Subject: FW: Proposed Development 70A Tarrant Street Arundel BN18 9DN Reference No. AB/118/20/PL

I am writing to object to the above Proposed Development as below:

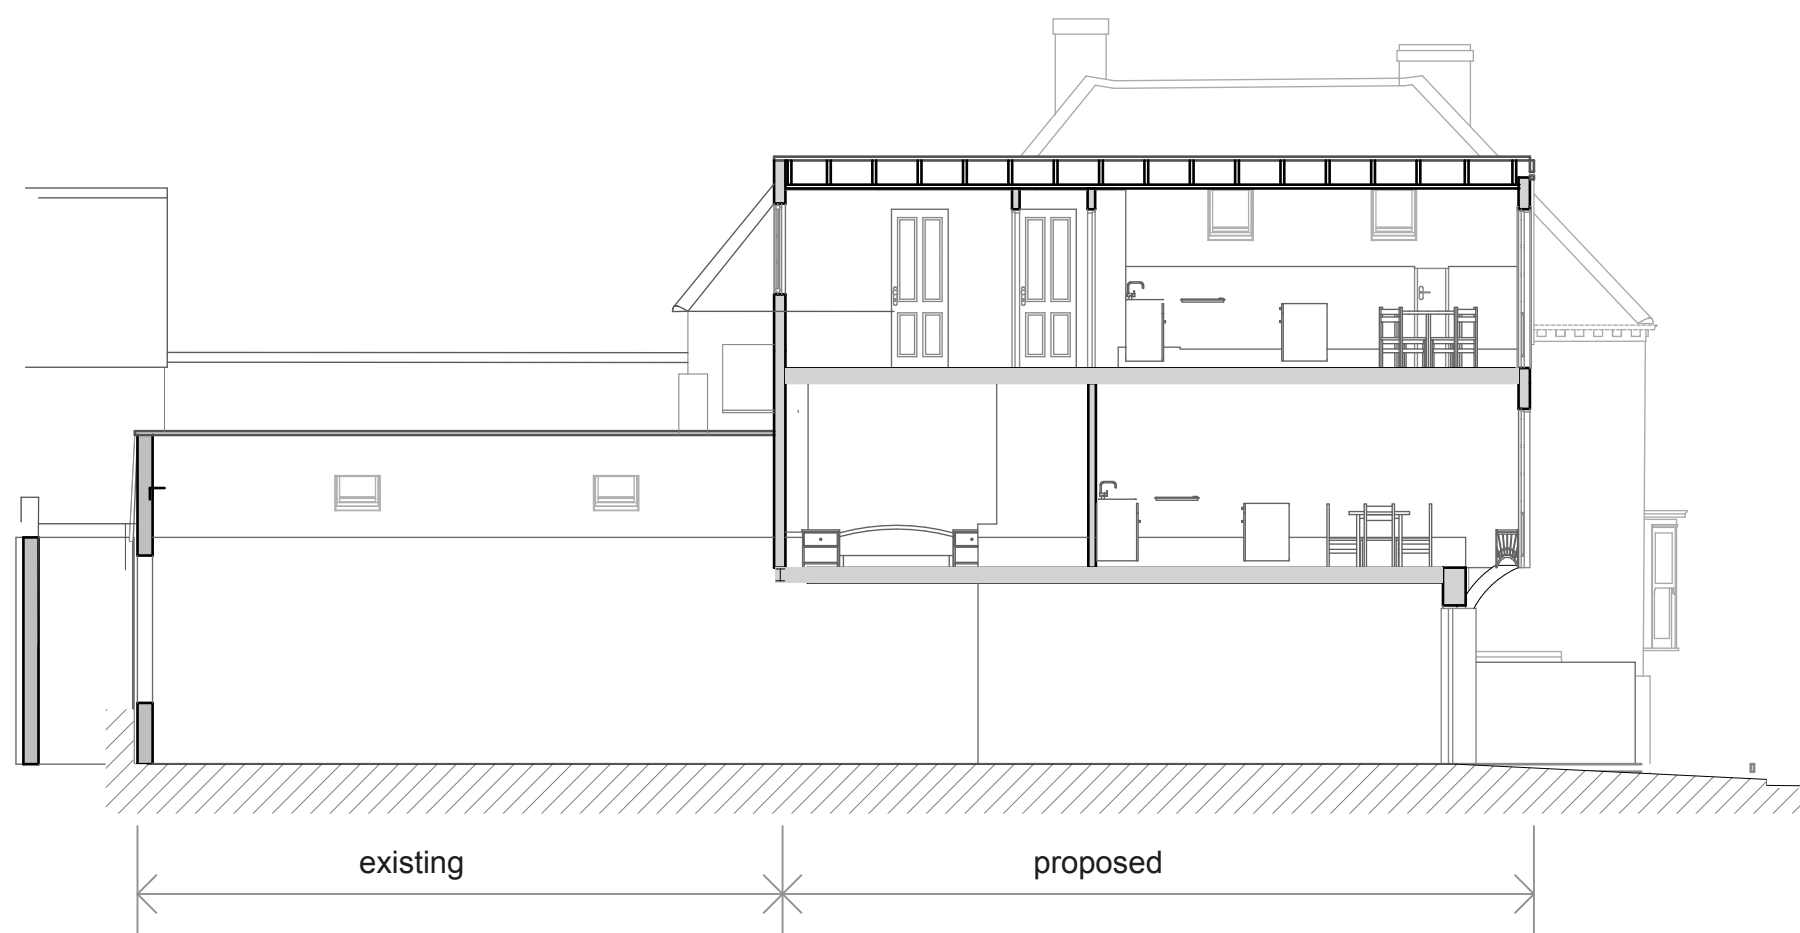
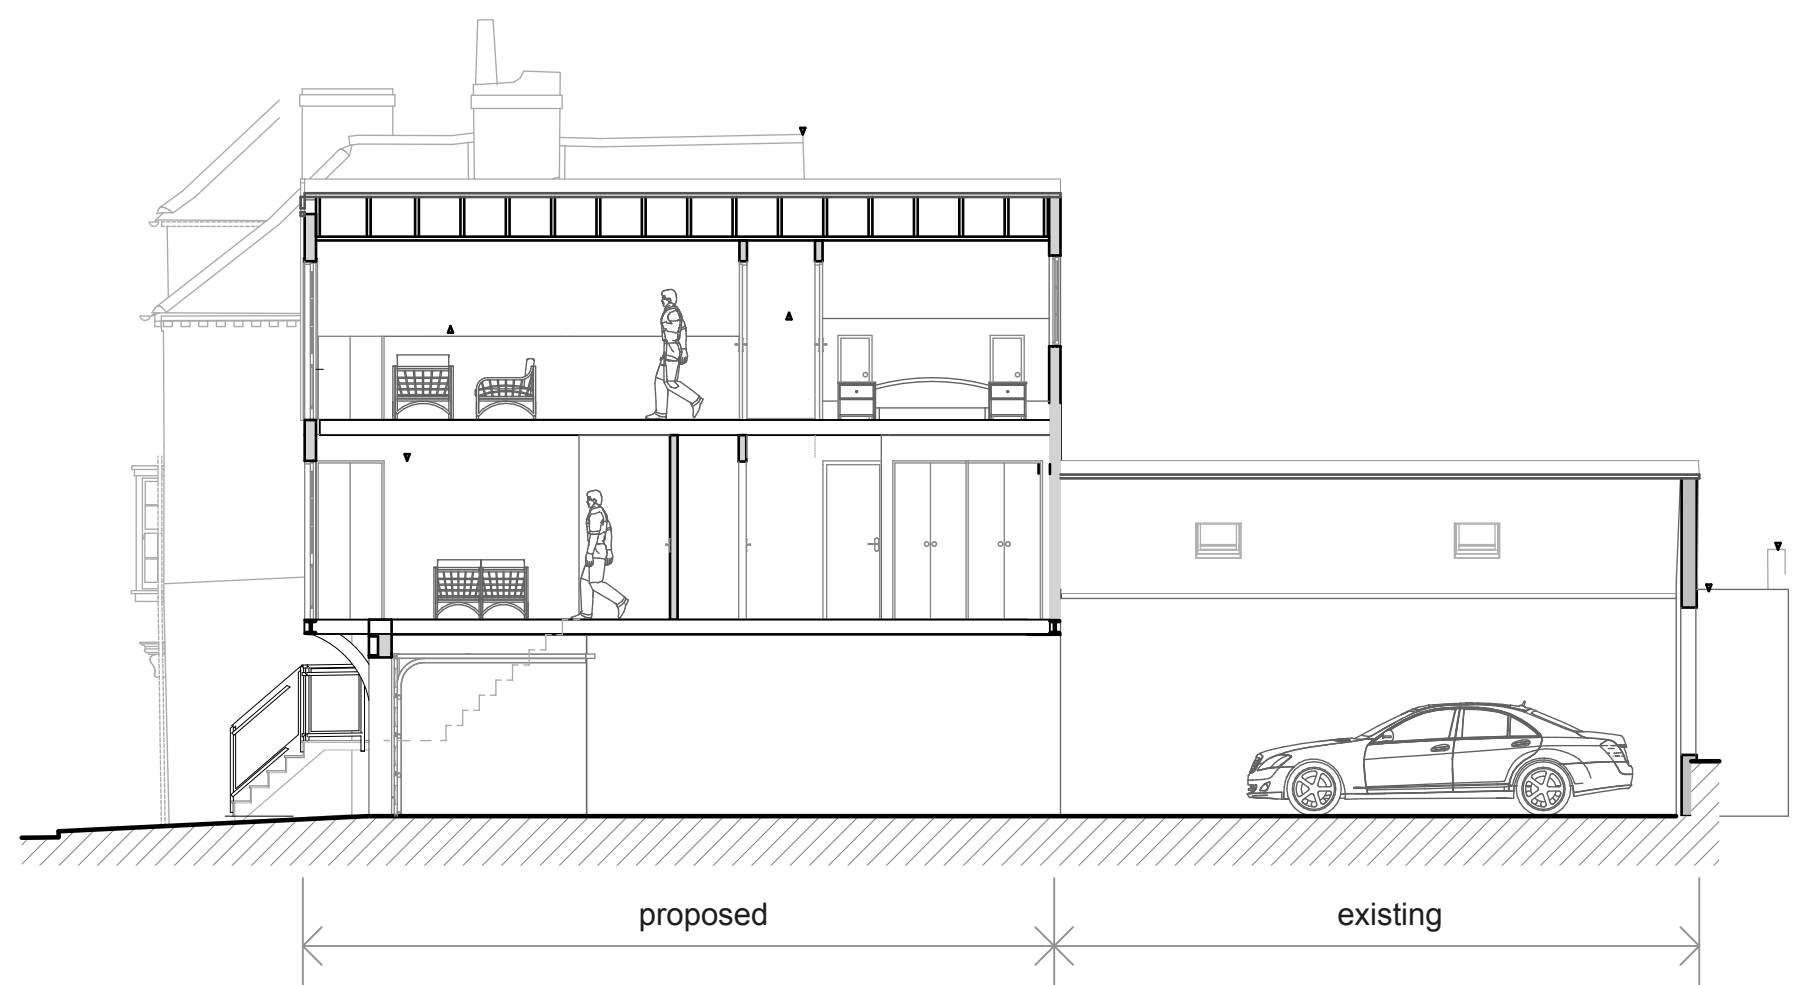
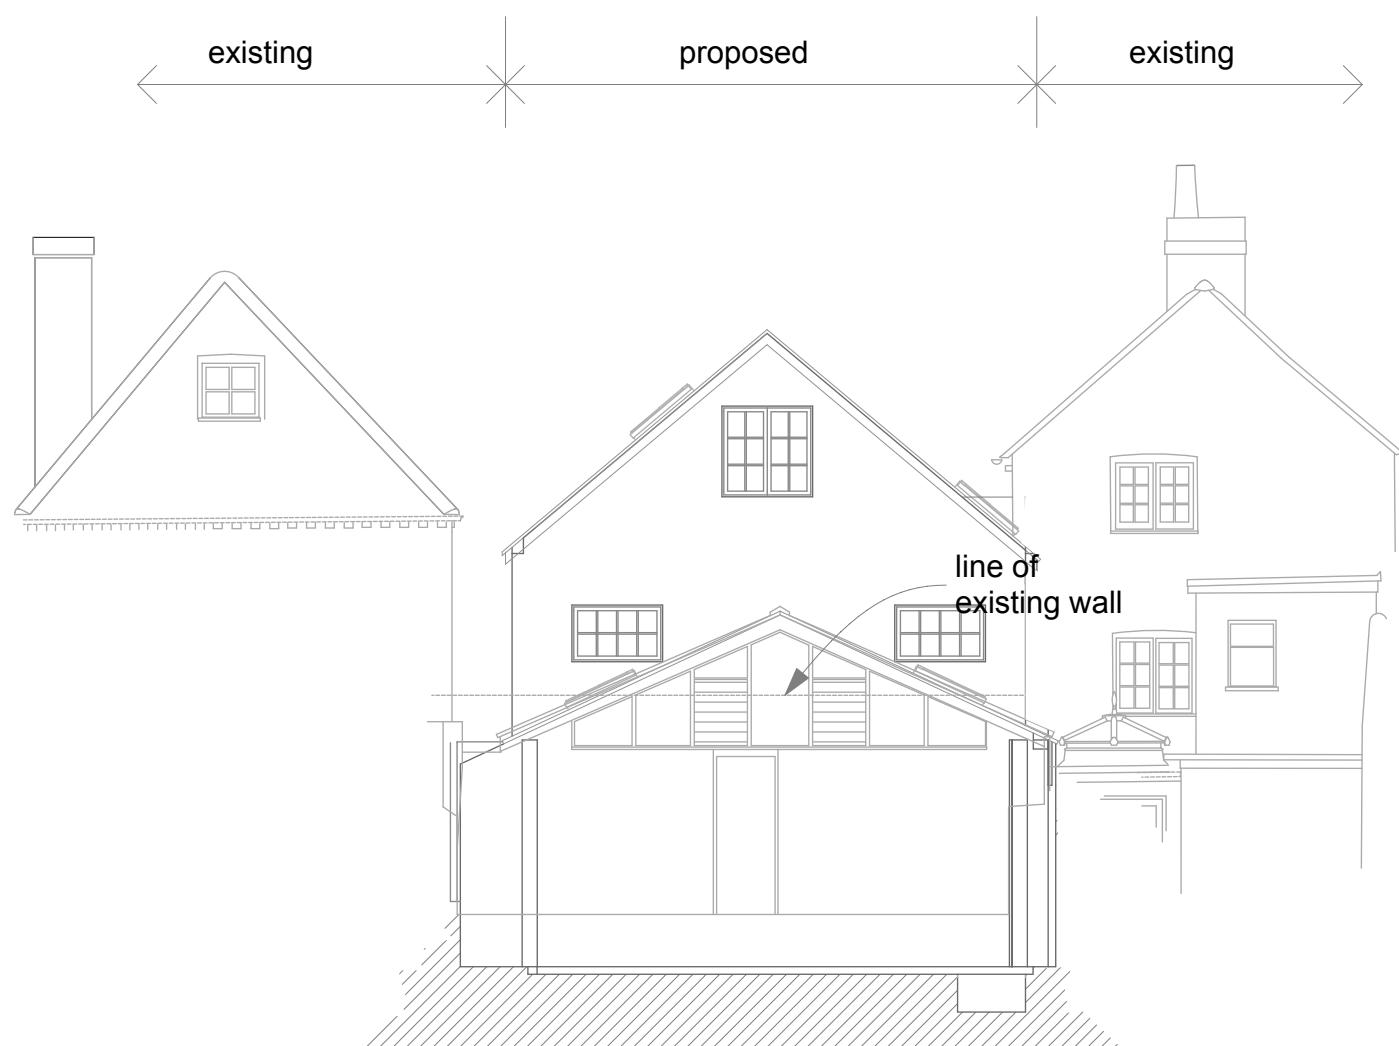
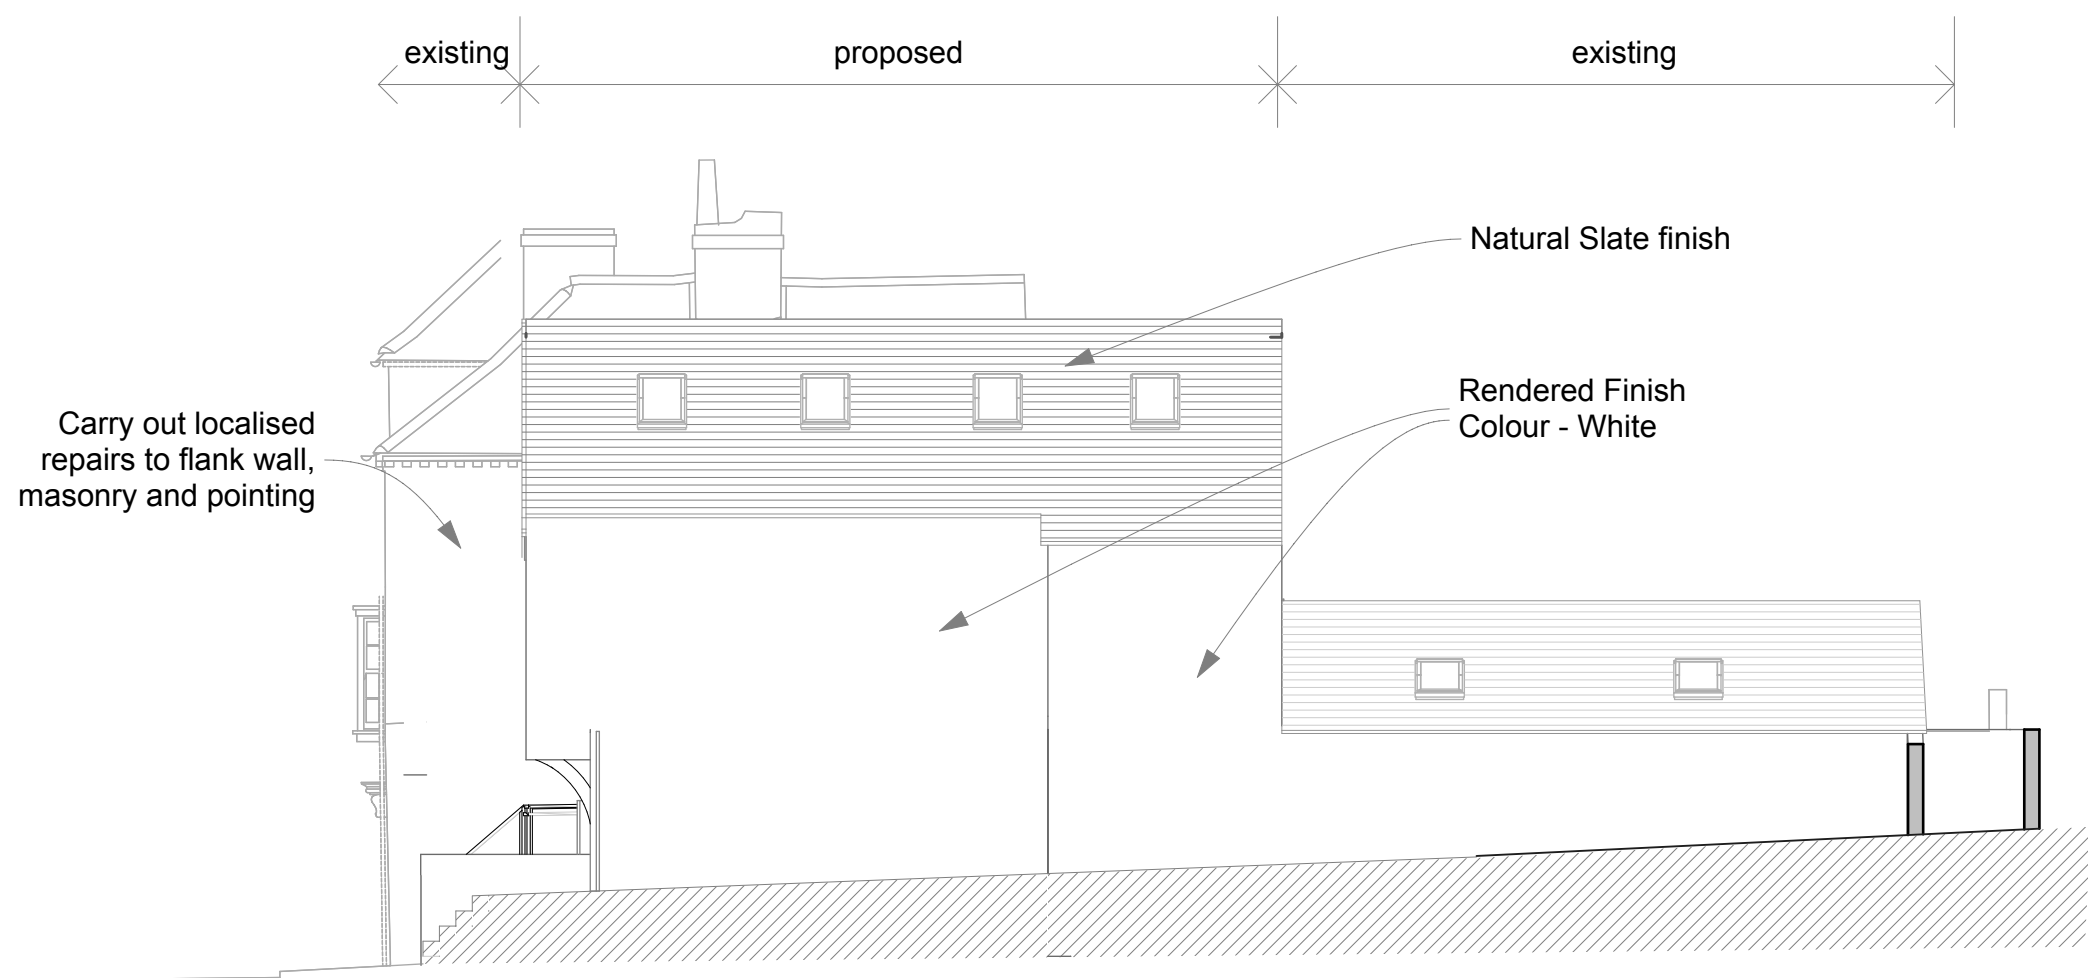
THE DATUMS will provide the needed clarification of the actual proposed ridge height which currently differs between plan 682/PL/200 Front/South-East elevations as proposed showing the top of the proposed ridge the same height as ridge to Number 70 or the much lower ridge height shown on plan 181390/05 with title Sections - proposed.

a) There is overlooking from the new north elevation containing 3 No large new windows (Not dimensioned).

b) There is additional overlooking onto Number 64 and its neighbours from 4 roof lights without dimensions in the east elevation of the main sloping roof.
